MINI STORAGE WAREHOUSE SITE

AS BUILT ENGINEERS CERTIFICATION

DRAWN BY: O.E. WATTS	APPROVED BY:	REVISIONS 1-18-21 REVISED PER COUNTY COMMENTS	DEW	PROJECT	16140 OLD DENVER ROAD	SHT. NAME	CONSTRUCTION DOCUMENT	SHT. NO.	2
DATE: 10-23-19	PROJ. NO.	4-21-21 REVISED PER COUNTY COMMENTS	DEW	PART NW1/4 SEC. 26, T.11S., R.67W. 6TH P.M.	EL PASO COUNTY	GRADING AND EROSION CONTROL PLAN	OF	5	
DWG. NO.: 17-4858-04	DWG.	6-25-21 REVISED PER COUNTY COMMENTS	DEW						
SURVEYED BY: DEW, ESW, 10-24-16, 1-24-17, 4-18-19		12-5-22 AS BUILT BUILT POND	DEW

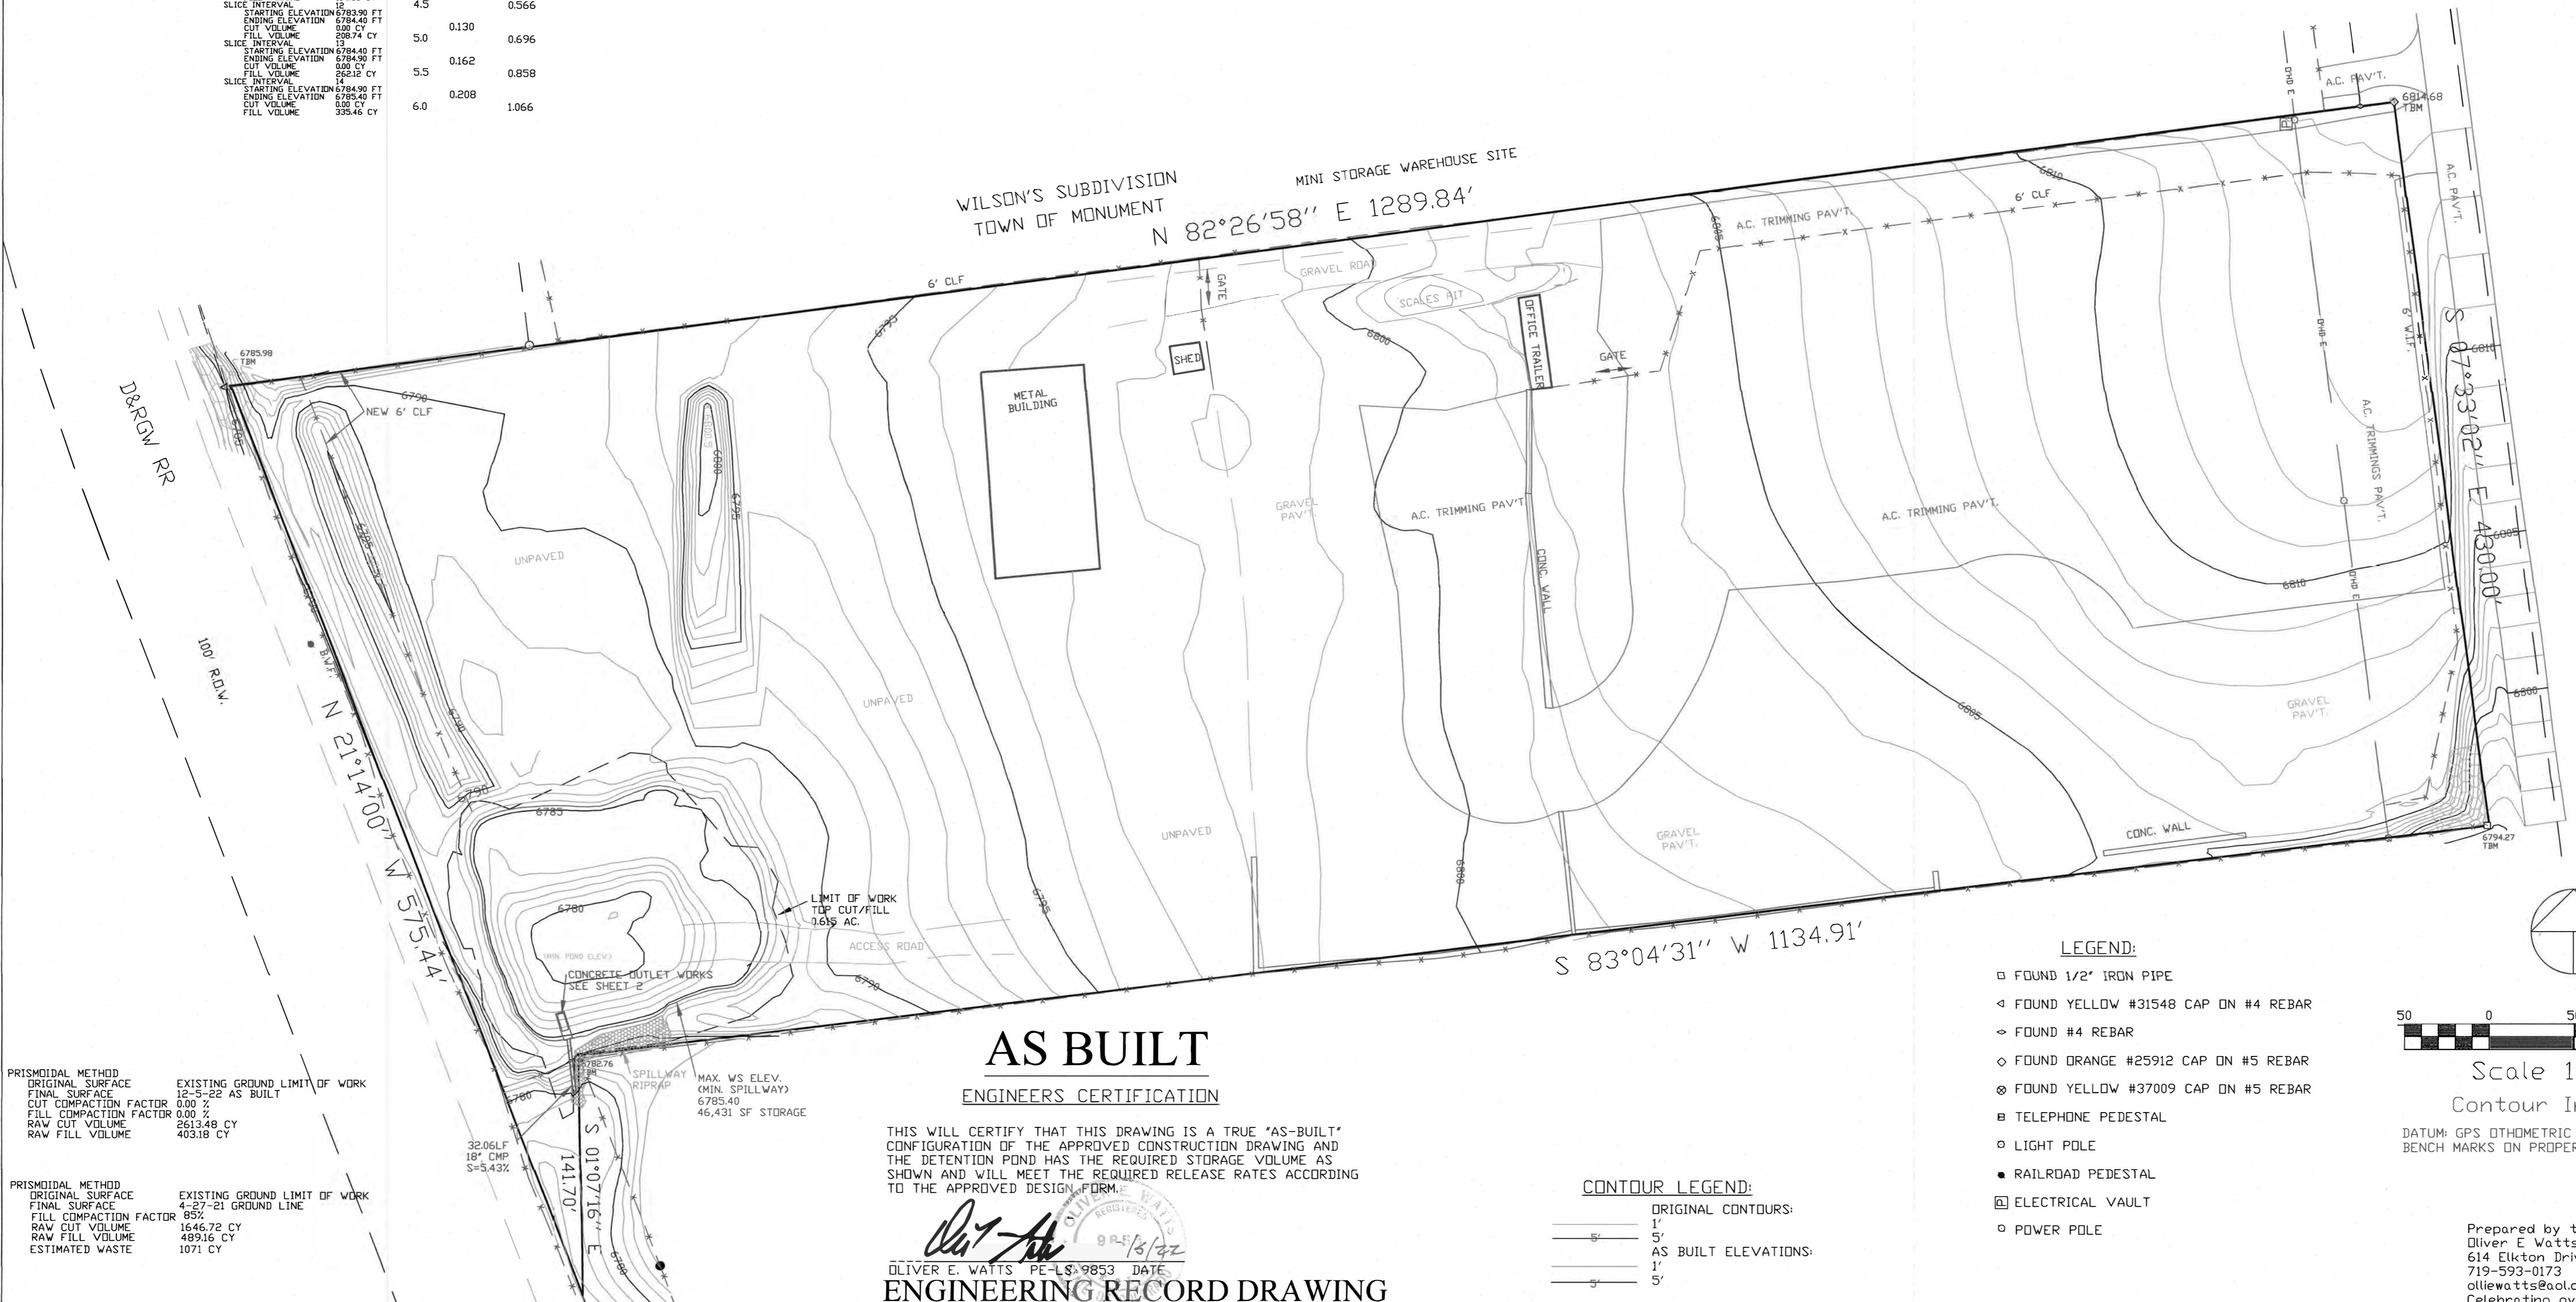
pond bottom should not be lower than micropool inlet. regrade pond bottom to promote positive drainage to the outlet structure and to prevent water rights concerns.

update sheet numbers

show/label all pond components including new riprap/rundown

show slope

show slope

not installed as shown on as built

include riprap size used

please change one of the contour line types so that we can differentiate between original and as built elevations.
